**APPLICATION (“THE APPLICATION”) BY HIGHWAYS ENGLAND (“THE
APPLICANT”) FOR AN ORDER (“THE ORDER”) GRANTING
DEVELOPMENT CONSENT FOR THE A303 SPARKFORD TO ILCHESTER
DUALLING (“THE PROPOSED DEVELOPMENT”)**

**REQUEST FOR COMMENTS FROM ALL INTERESTED PARTIES ON THE
APPLICANT’S RESPONSE TO THE SECRETARY OF STATE’S ‘MINDED
TO REFUSE’ LETTER**

**SUBMISSION BY SOUTH SOMERSET BRIDLEWAYS ASSOCIATION
(“SSBA”)**

FIGURE 2.5  
HAZLEGROVE JUNCTION UNDERBRIDGE  
GENERAL ARRANGEMENT

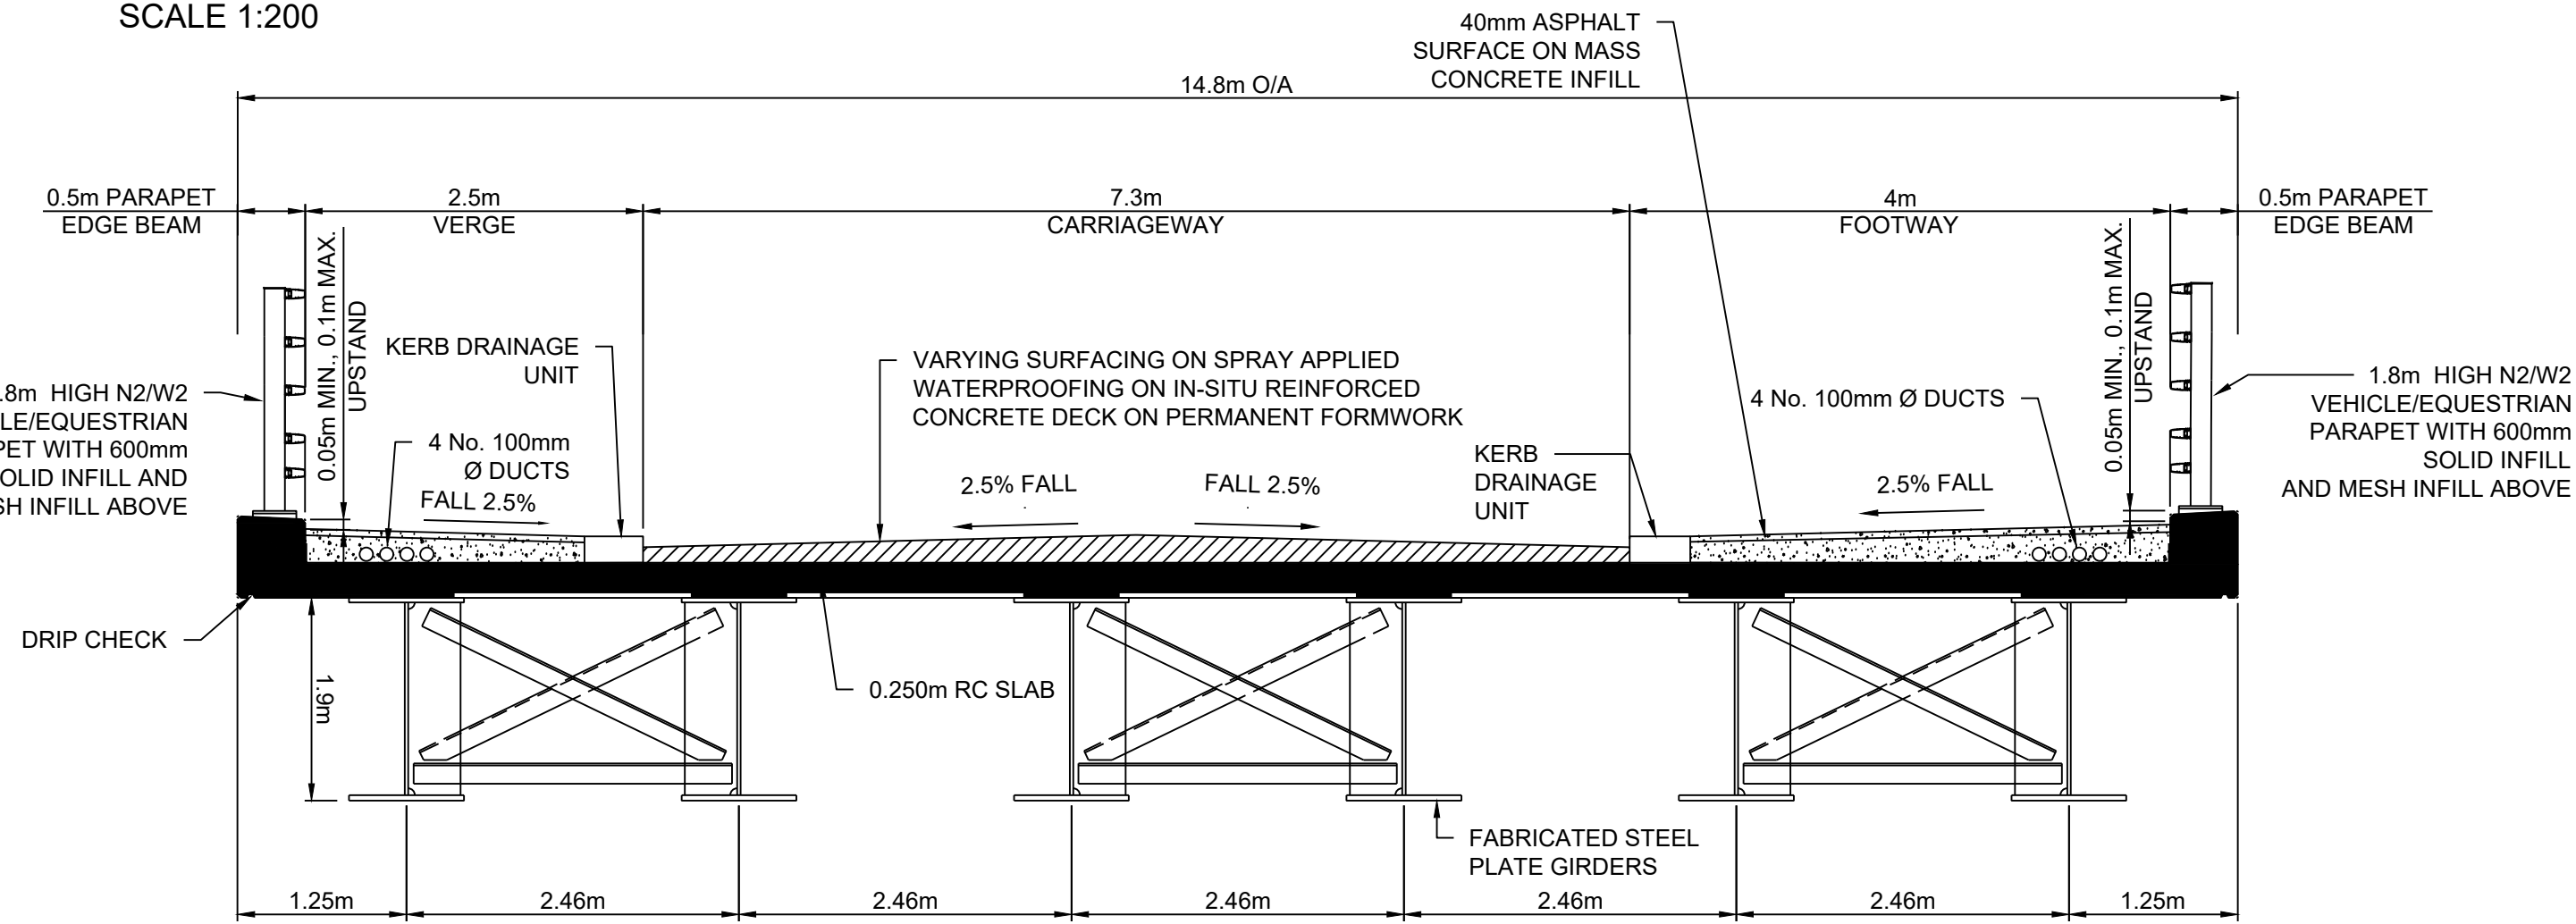
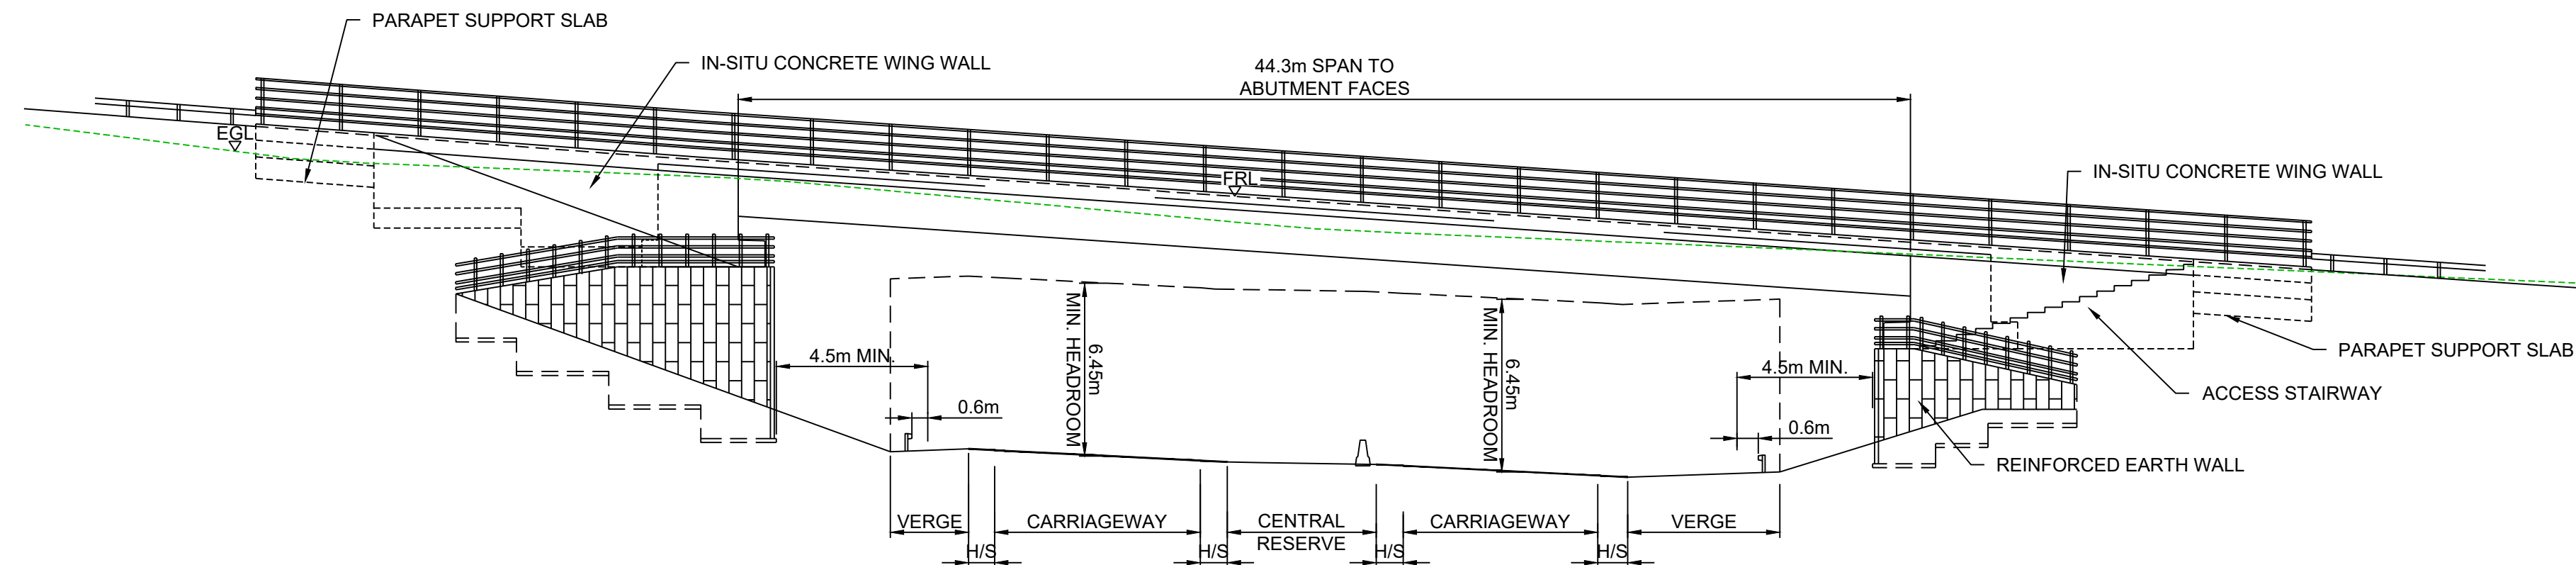
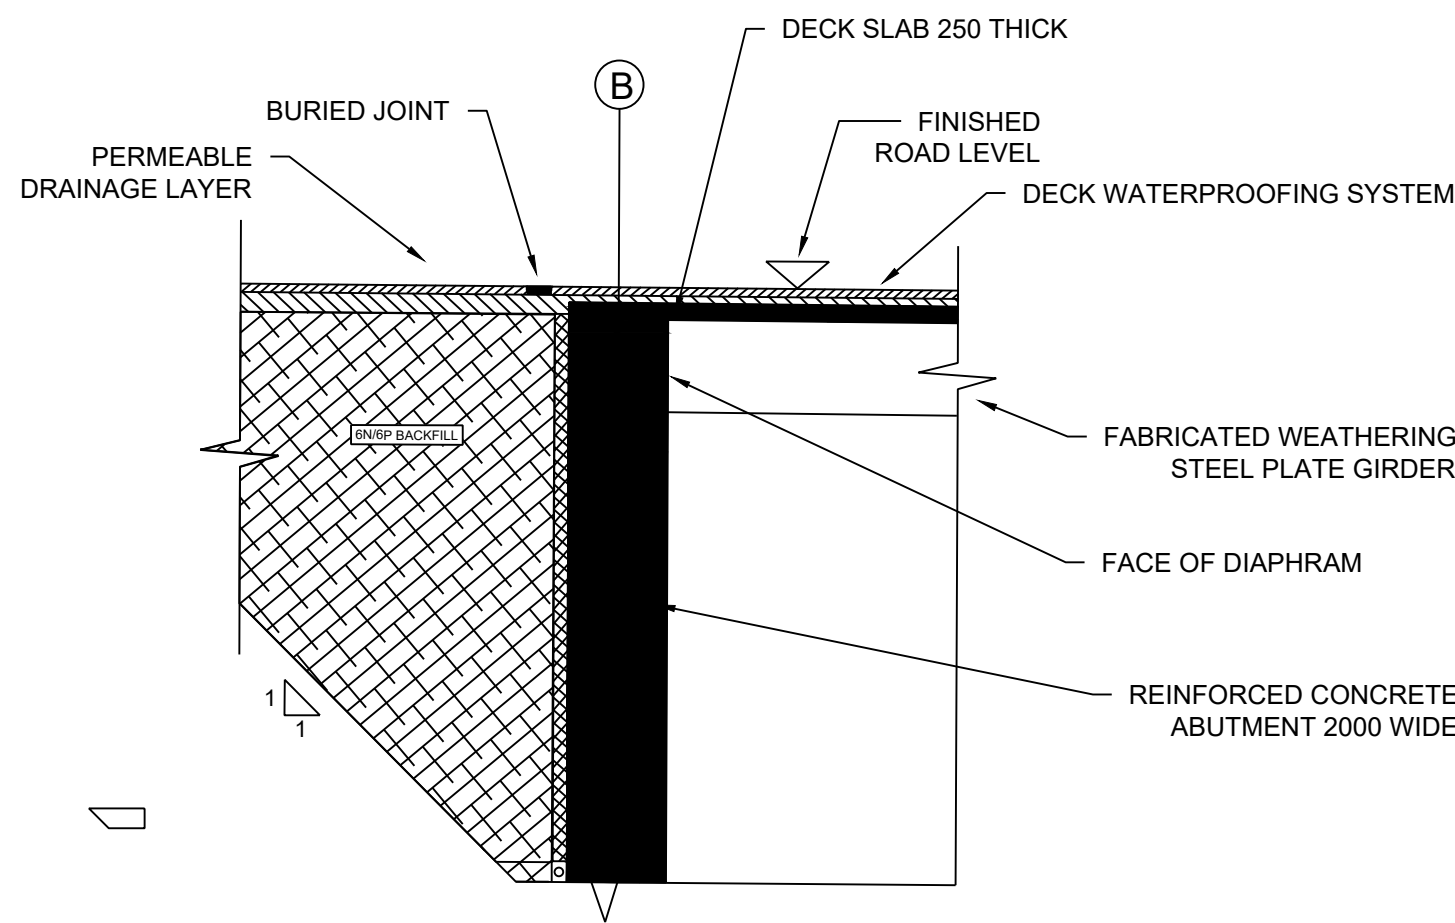
SSBA agrees with the ExA's finding that the Applicant's proposals with respect to lighting of the proposed new underbridge are inadequate and fail to meet the needs of NMUs. SSBA is pleased that the Secretary of State is minded to agree that night-time lighting, on the approaches as well as in the underpass itself, is a reasonable step that is essential to minimise the risk of road casualties and improve road safety and, accordingly, to agree with the ExA's recommended change to the DCO.

SSBA notes that the Applicant has not disclosed the internal dimensions of the proposed underbridge nor the materials to be used in its construction. SSBA considers the NMU route should be separated from the motorised vehicular carriageway(s) and screened to protect NMUs from vehicle lights and noise in the underpass. Without such protection, NMUs (especially equestrians) are at risk of being distracted, causing a road safety risk for all users. The internal dimensions should therefore be a minimum of 5 meters wide and 3.5 meters high exclusive of screenings. Ideally, the NMU route should pass through a separate side tunnel with an anechoic inner surface. This would substantially mitigate the safety risks for both NMUs and motorised traffic and improve the attractiveness of the route for NMUs.

At approximately 25 metres, the underbridge will be unusually long. It is therefore especially important to make it as attractive as possible for NMUs.

Appendix 1 APPROPRIATE MITIGATION FOR STOPPING UP OF TERMINUS OF BRIDLEWAY Y 30/28 (EASTMEAD LANE)

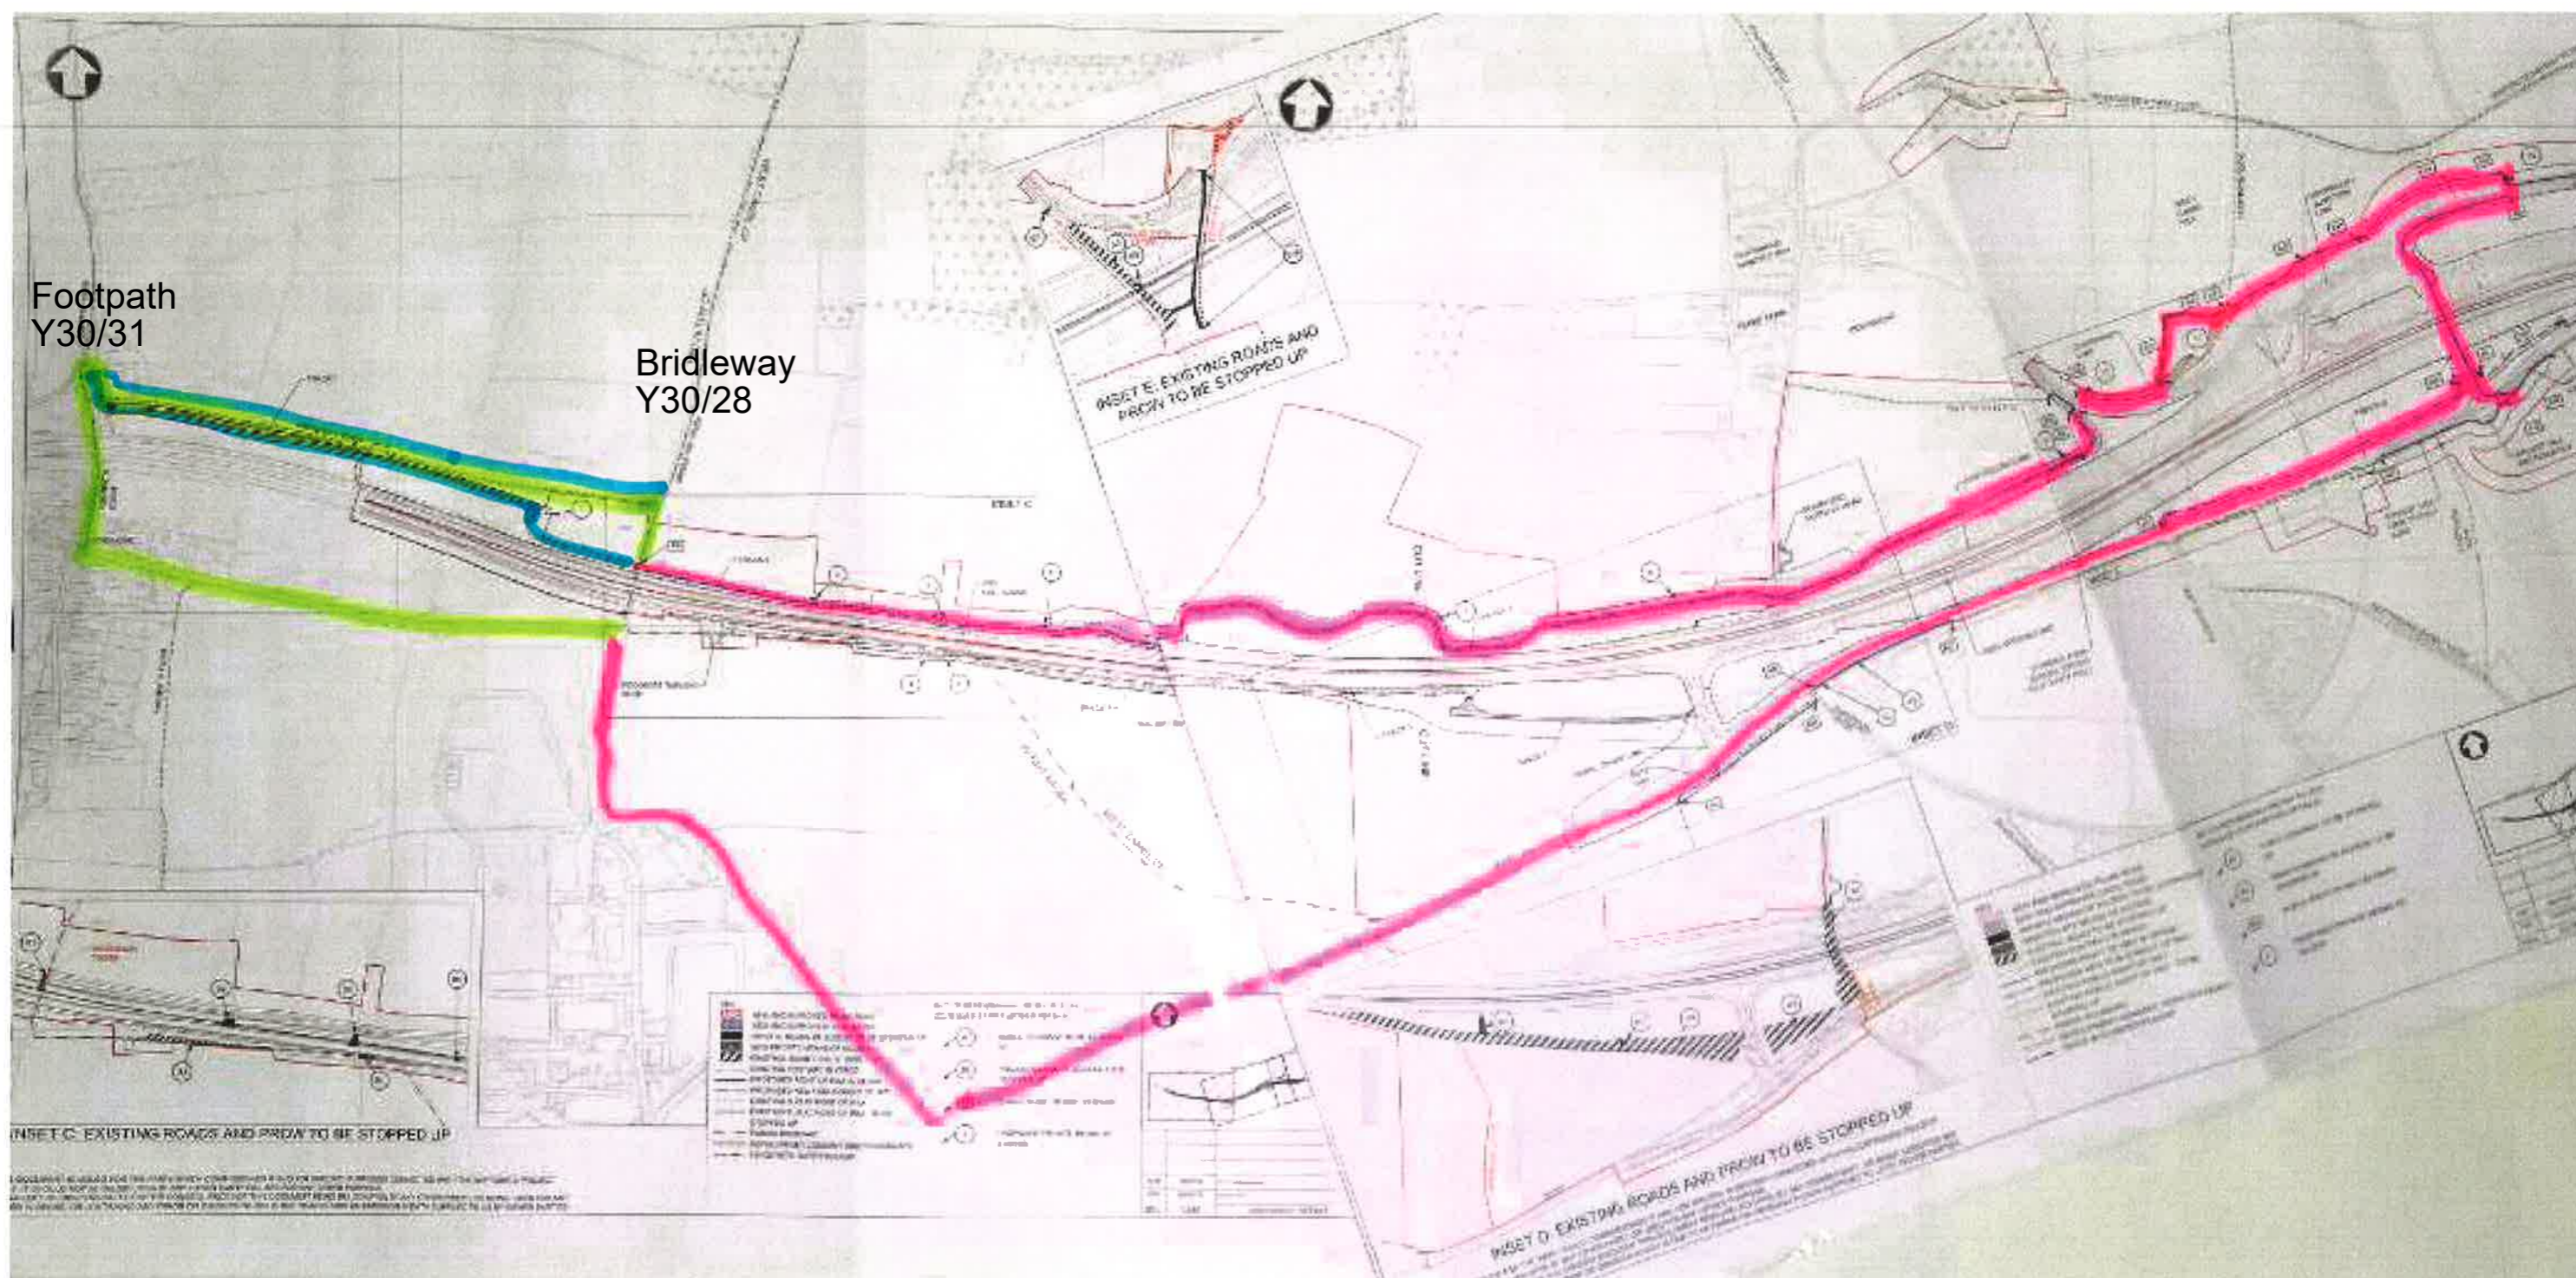
SSBA considers the Applicant's proposed mitigation to be unrealistic and wholly unsatisfactory. In SSBA's opinion, a diversion of this length is unreasonable and may be expected to deter NMUs from using the Eastmead lane (Y30/28) definitive route or encourage them to take unnecessary risk by crossing at grade.

SSBA is therefore pleased that the Secretary of State has taken note of the more effective mitigation we have proposed jointly with South Somerset District Council (SSDC) and Somerset County Council

(SCC) to provide an alternative NMU route over the Higher Farm Lane overbridge. This would involve a detour of only 1.5 kilometres, and could be readily delivered by:

1. The Applicant dedicating restricted byway rights on a suitable route within the DCO boundary from Eastmead Lane to Higher Farm Lane; and
2. SCC making the requisite orders to record the restricted byway rights along Higher Farm Lane (including the overbridge) pursuant to the outstanding DMMO application (SCC reference 863M) and to connect the route in 1. above to Higher Farm Lane.

Appendix 2 POTENTIAL LEGACY ISSUES IF ONLY PARTIAL REVOCATION OF 1996 SRO

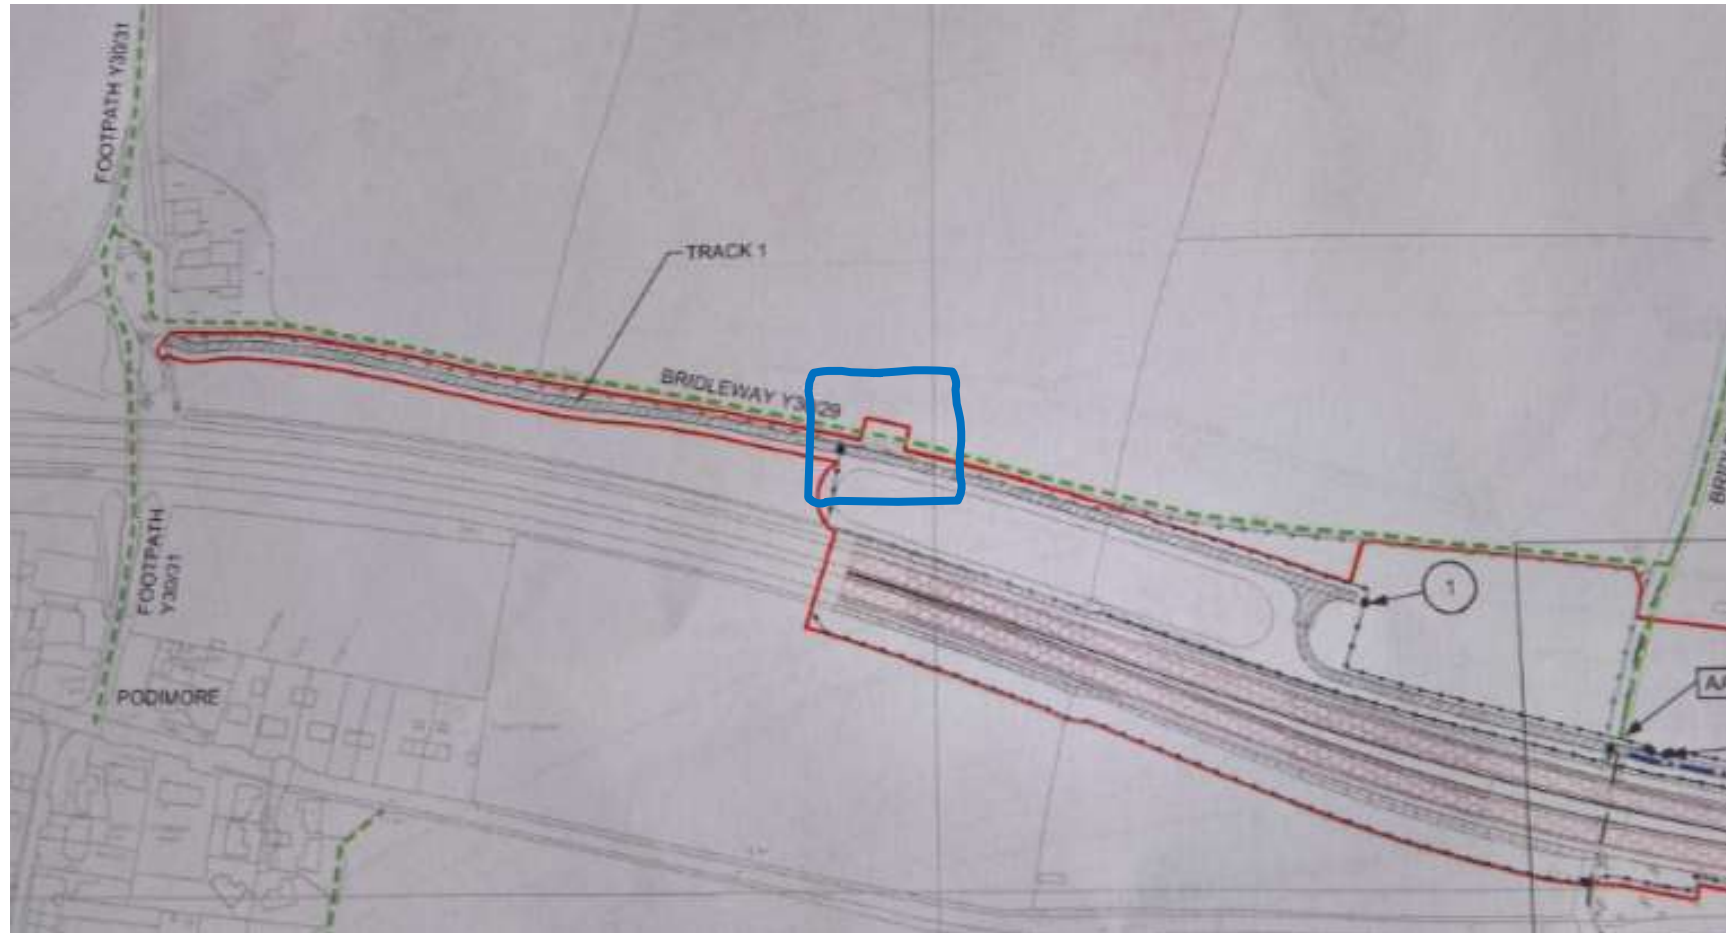
This proposal, if implemented, would have the additional benefit of resolving the failure to deliver bridleway Y30/29 in accordance with the 1996 Side Roads Order.
